DECISION DELEGATED TO HEAD OF PLANNING

Application No: H06-0134-22 **Applicant:** Mr A Hay
Proposal: Residential Development - Erection of Dwelling
Location: Adj. Park View Dawsmere Road Gedney Drove End
Terminal Date: 5th April 2022

CASE OFFICER ASSESSMENT

Client:	MRE A. PRY.
Issuing:	FLOOR PLANS & ELEVATIONS
Job Ref:	39932-21.
Drawing No:	01A.
Date:	JANUARY 2022.
Drawn:	S.D.

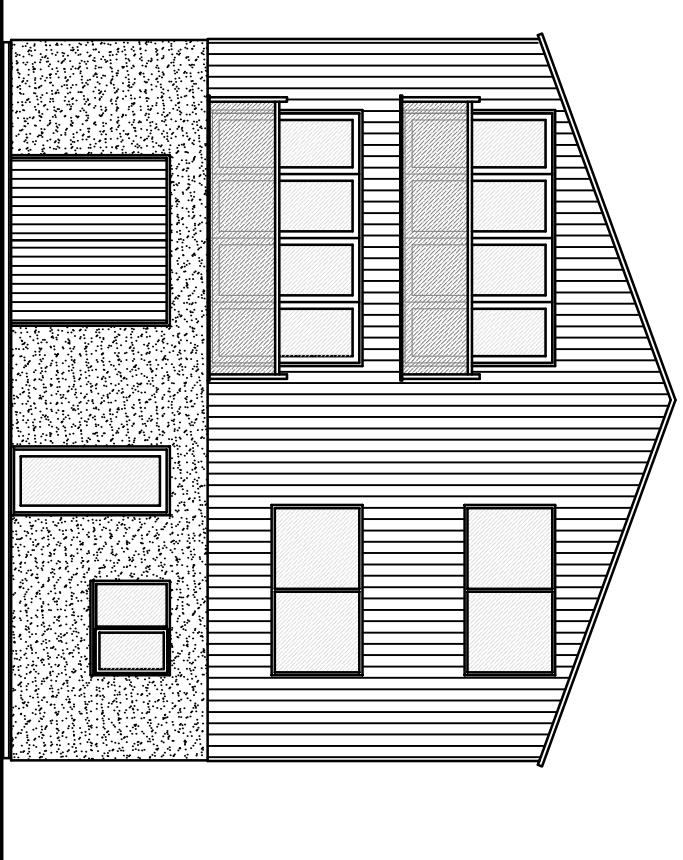
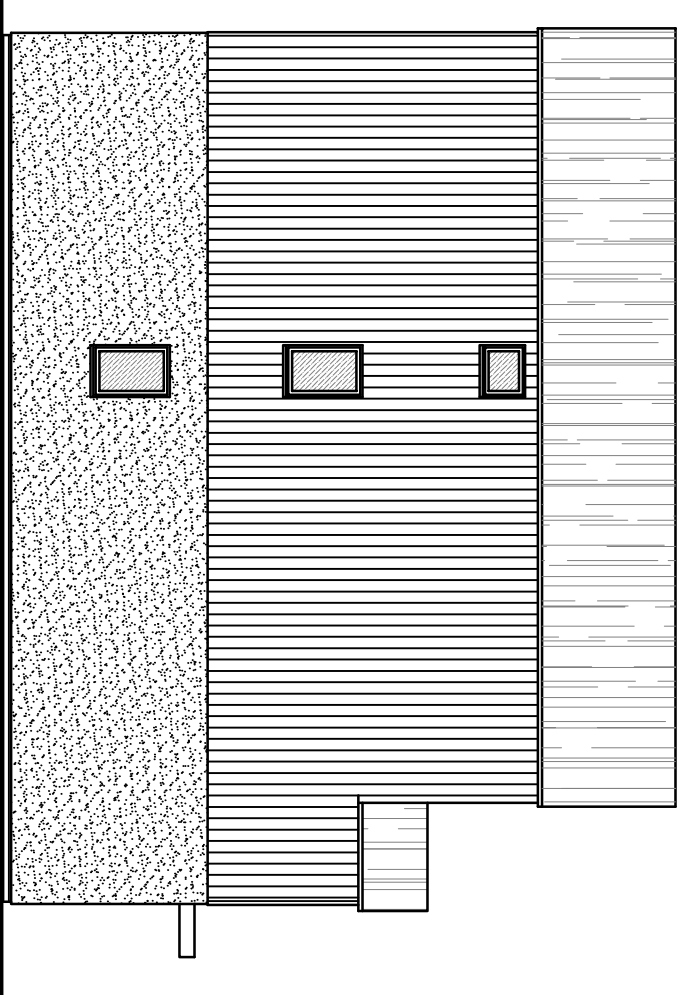
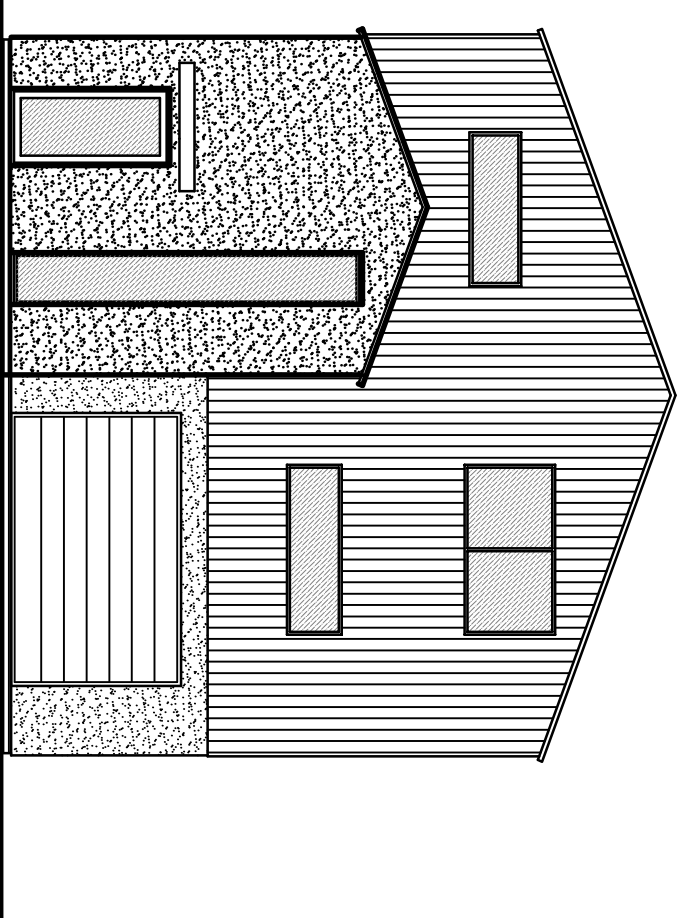
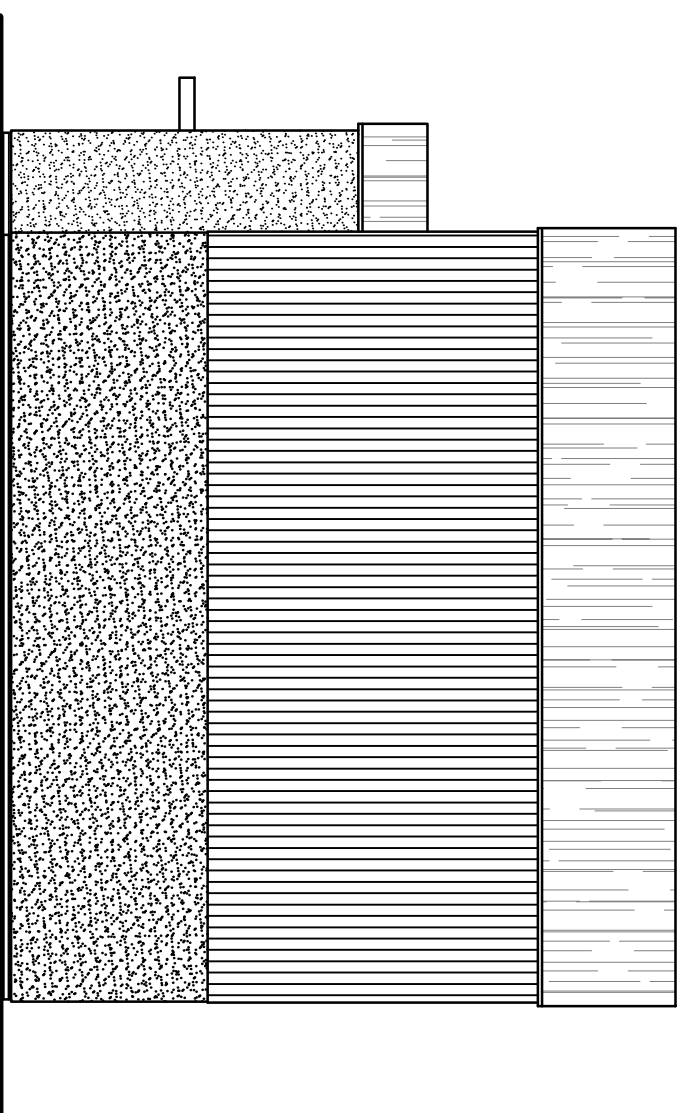
Following the amendments to this application Council remove the objection on overshadowing. However they do still request the materials are more in keeping with the surrounding properties.

- Not in keeping because not brick built;
- Overshadowing;
- Overlooking/lack of privacy.

The proposed dwelling is two storey with an integral garage and living accommodation on the first floor. It is contemporary as opposed to traditional in terms of design. The exterior would be a combination of white render and vertical woodgrain wall cladding (stone grey). The roof would be Kingspan Insulated Composite Panels (dark grey). The fenestration would be aluminium (colour anthracite). However, existing development within the vicinity of the site is an eclectic mix in terms of type, period and materials. Taking this into consideration it is considered that it would not materially harm the existing character or appearance of this part of the village.

The proposed house is approximately 29 metres from Lime House and 8 metres from Park View. It has an obscure glazed shower room window on its north-western elevation at first floor level and no openings on its south-eastern elevation facing Park View. The principle openings are at the front and rear, including a Juliet balcony serving the lounge at the rear (no external balcony). It is considered that the amenity of neighbouring residents would not be materially harmed in terms of overlooking, lack of privacy, overshadowing, overbearing effect, etc, subject to appropriate boundary screening.

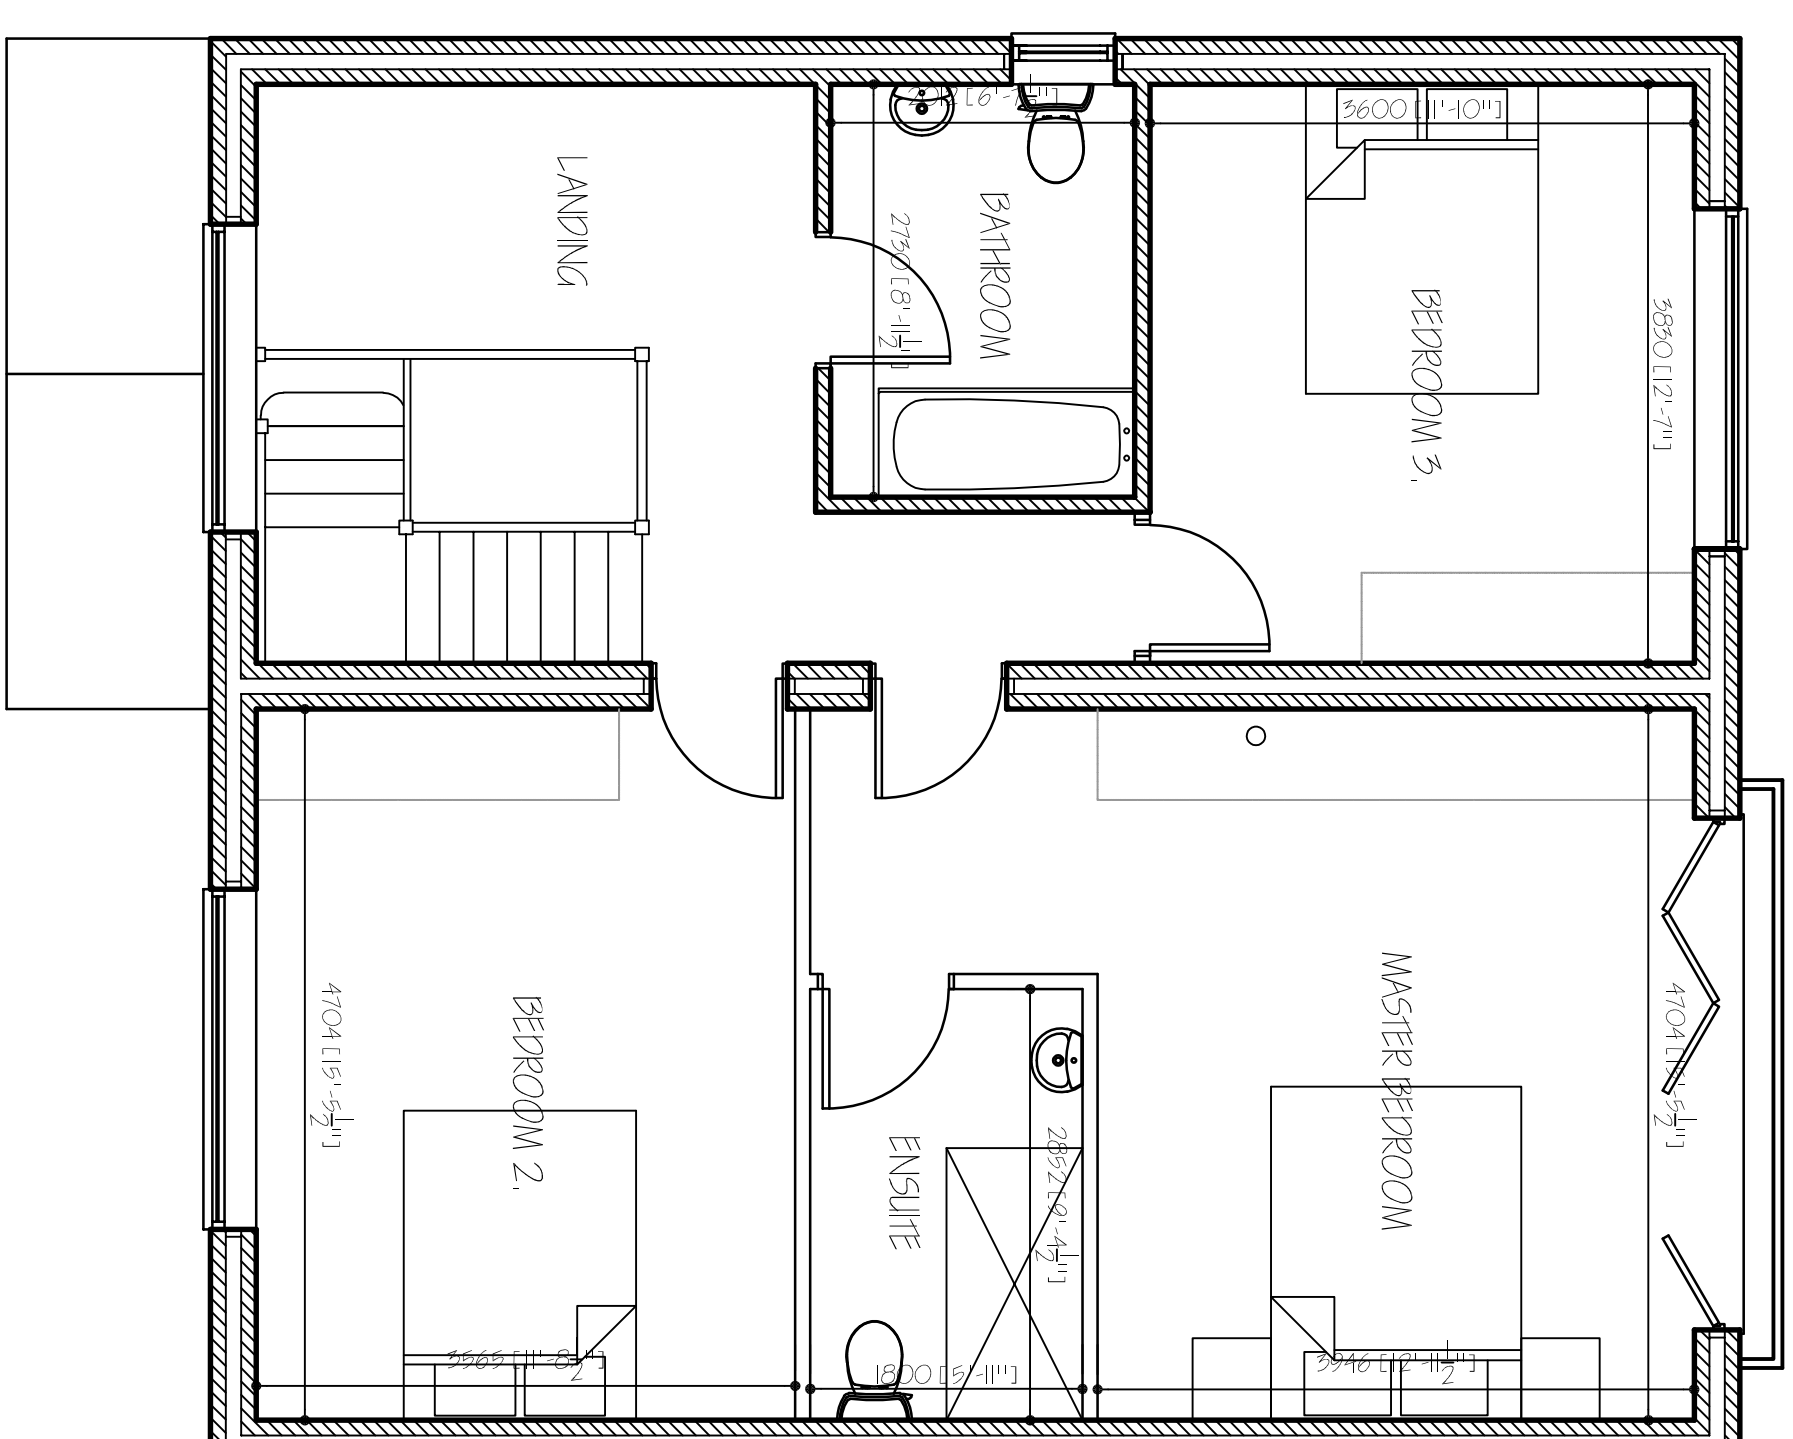
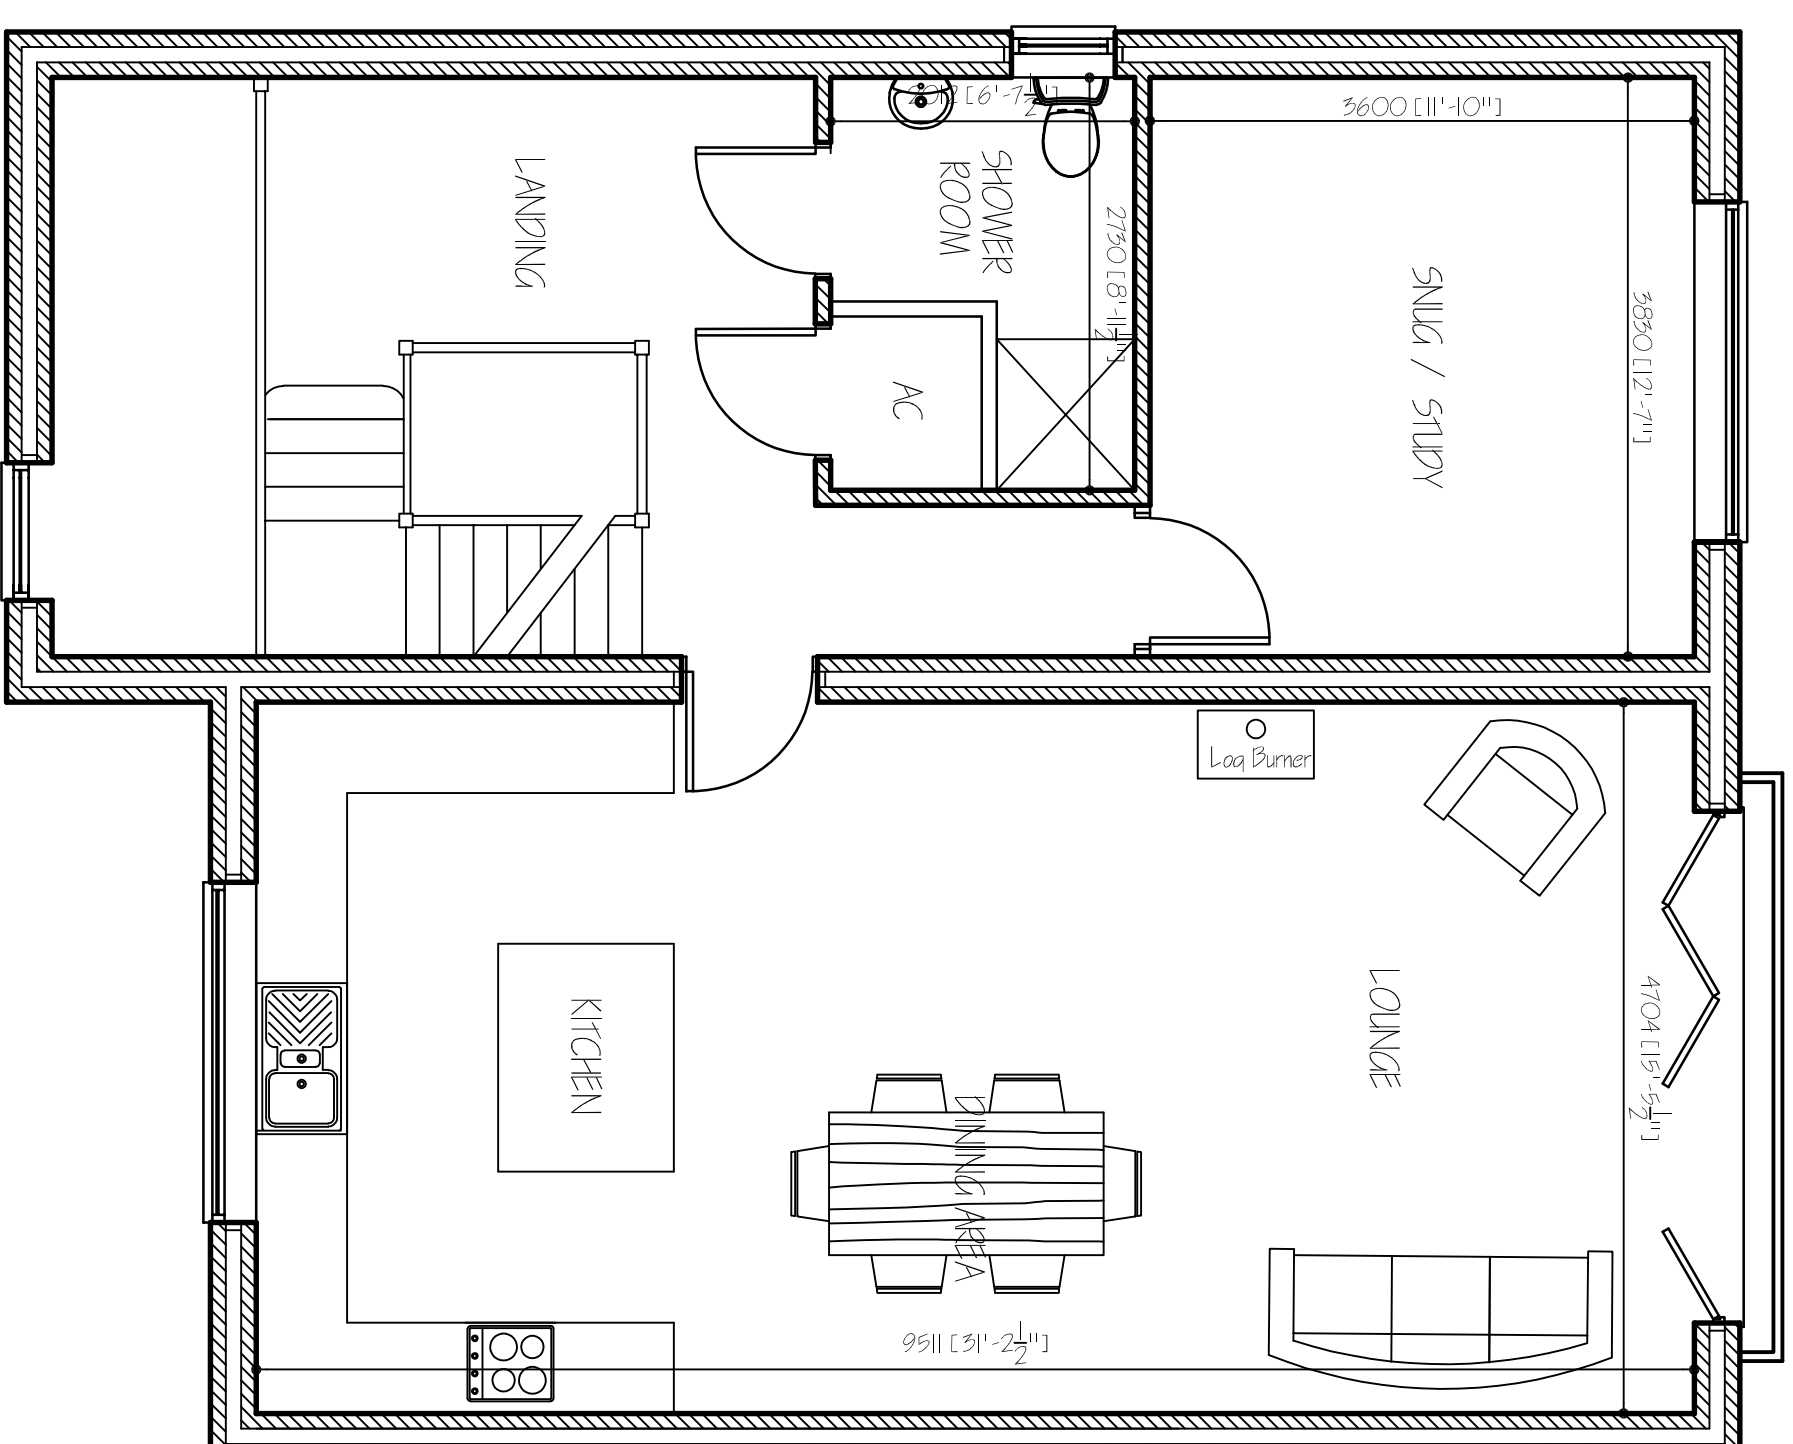
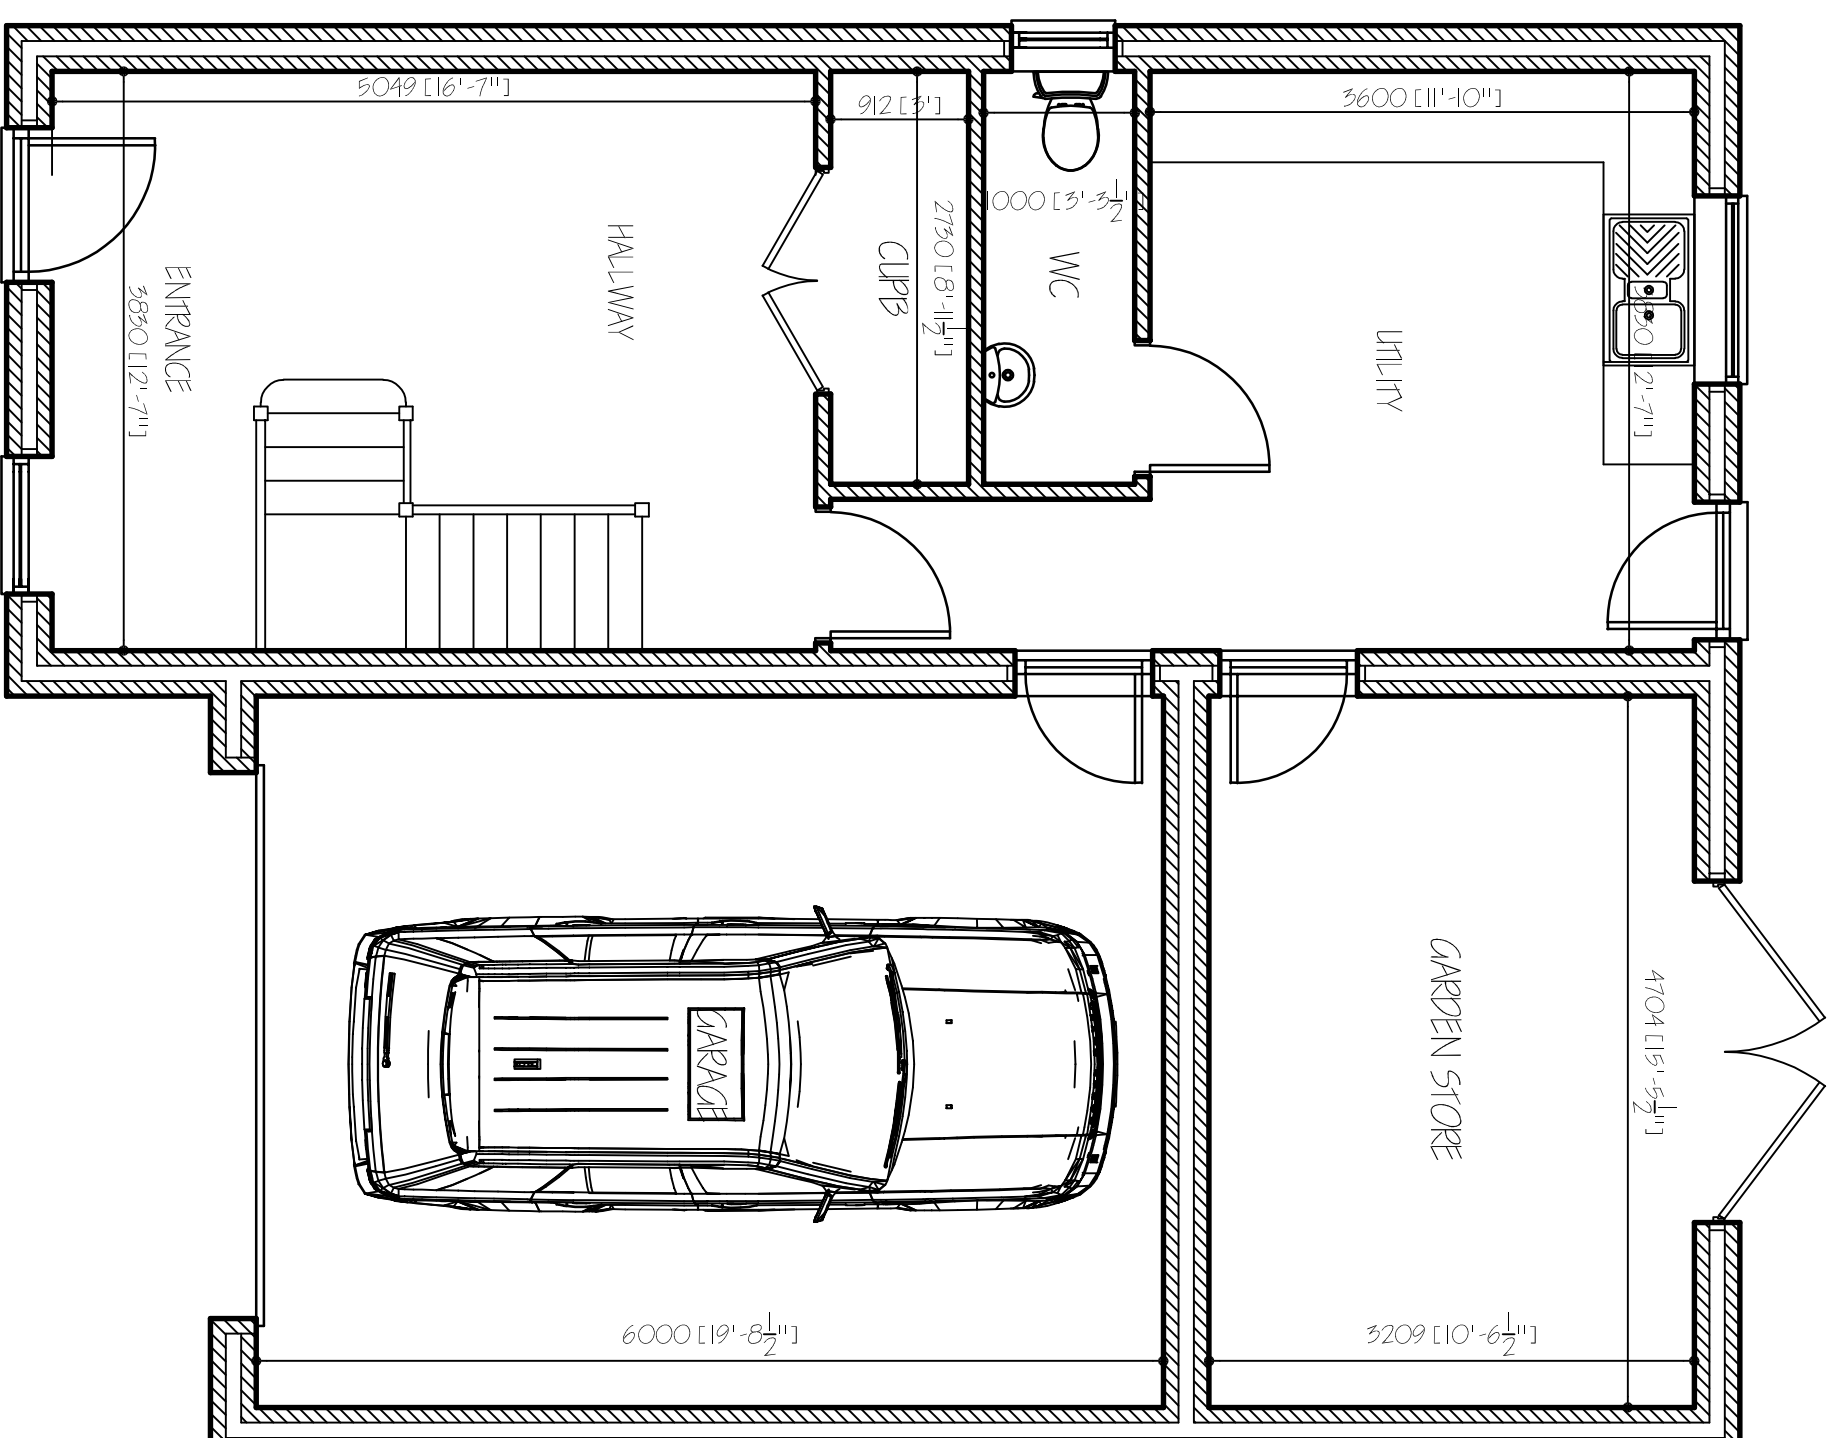
Concerning the second element, the SHDC Strategic Flood Risk Assessment Hazard Mapping shows that flood depths of greater than 1.6m impact on the application site when considering the 2115 0.5% breach scenario. On this basis, the Environment Agency has recommended that the dwelling must be a minimum of two-storey with no ground floor habitable accommodation.
